Proposal: Discharge of Conditions 3 (landscaping scheme), 5 (cycle parking) and 6 (sustainability and energy statement) of 17/01542/REM

Report type: Delegated

- 1.1. Planning permission was granted earlier this year (17/01542/REM) for the erection of units 1 and 3 within the Oxford Technology Park. This application is seeking approval of the details required by conditions 3, 5 and 6.

Oxford Technology Park  
 Cycle Shelter Details

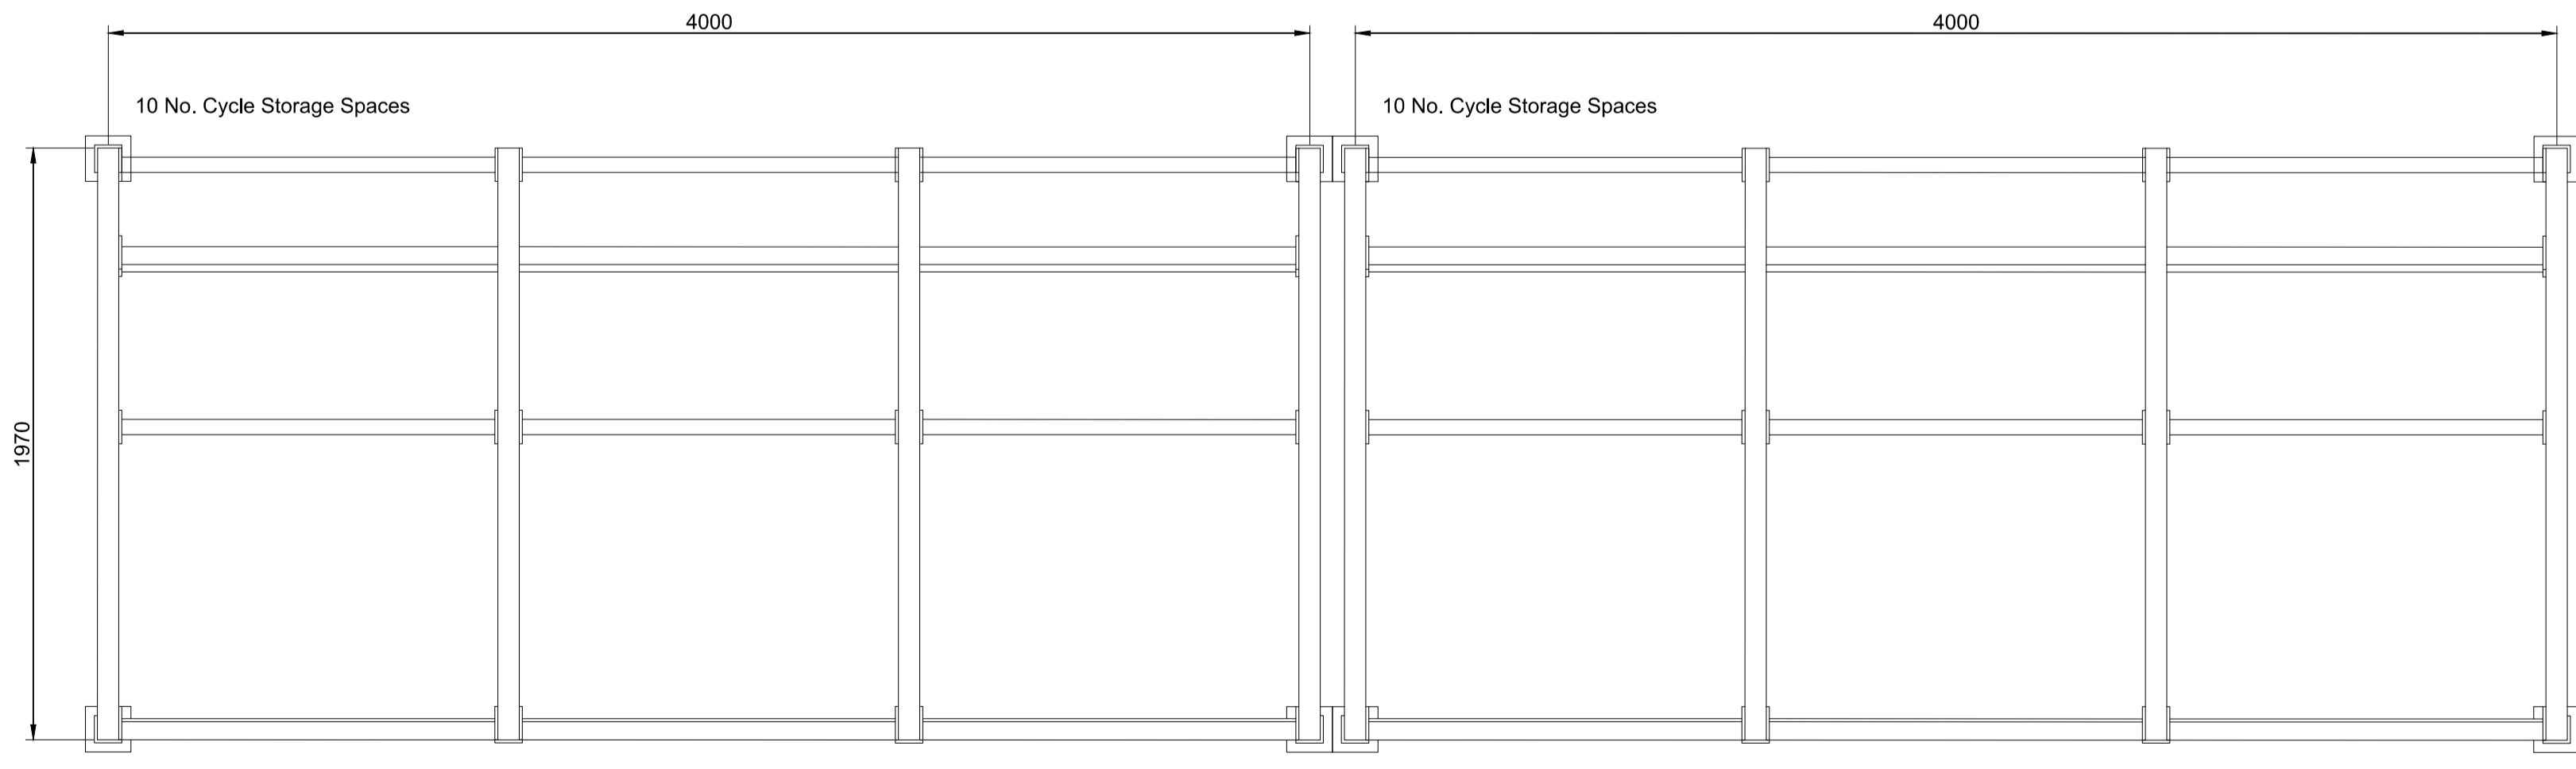
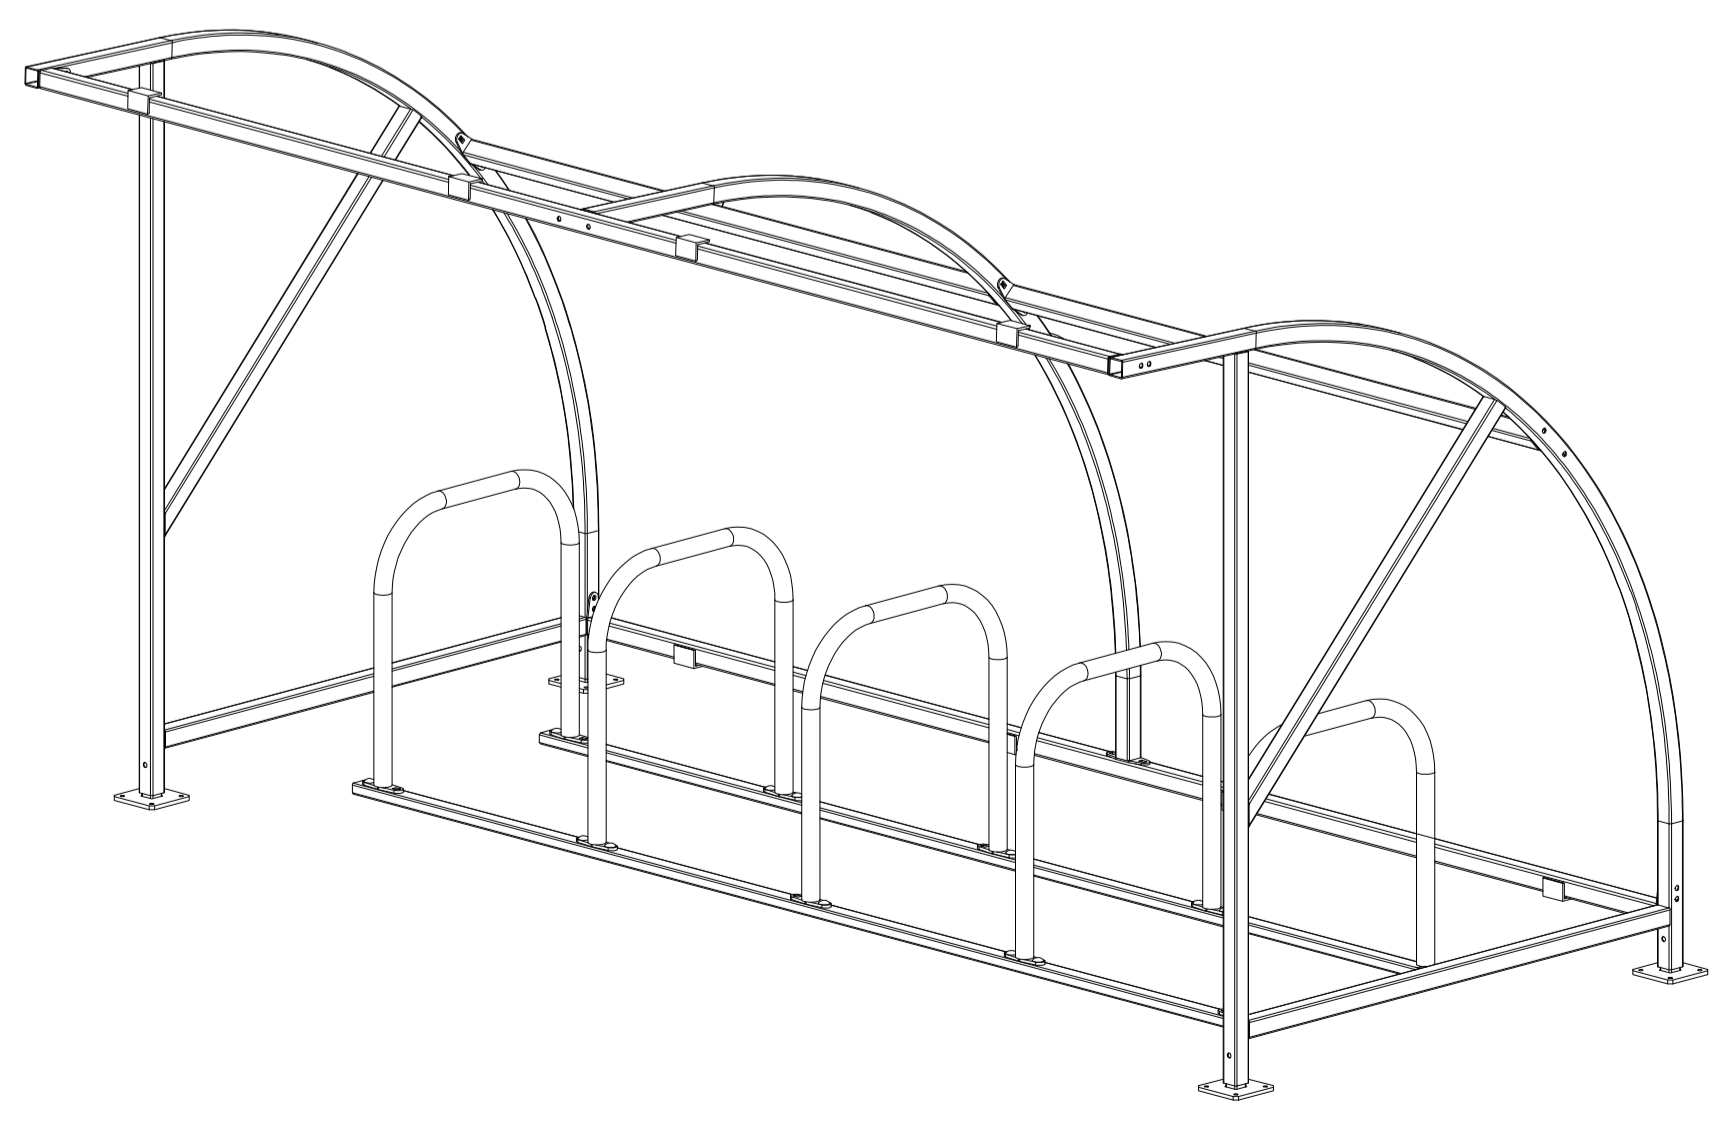
- 1.3. Condition 5 requested a detailed plan showing the cycle parking for plots 1 and 3 of the proposed development is approved by the Local Planning Authority. The condition was attached in the interests of maximising the opportunities for sustainable travel. The Local Highway Authority has not raised any objections to the details submitted within, which displays 30 spaces each for units 1 and 3 in covered shelters. I am also content with the siting of these shelters. It is therefore considered that this condition can be discharged.
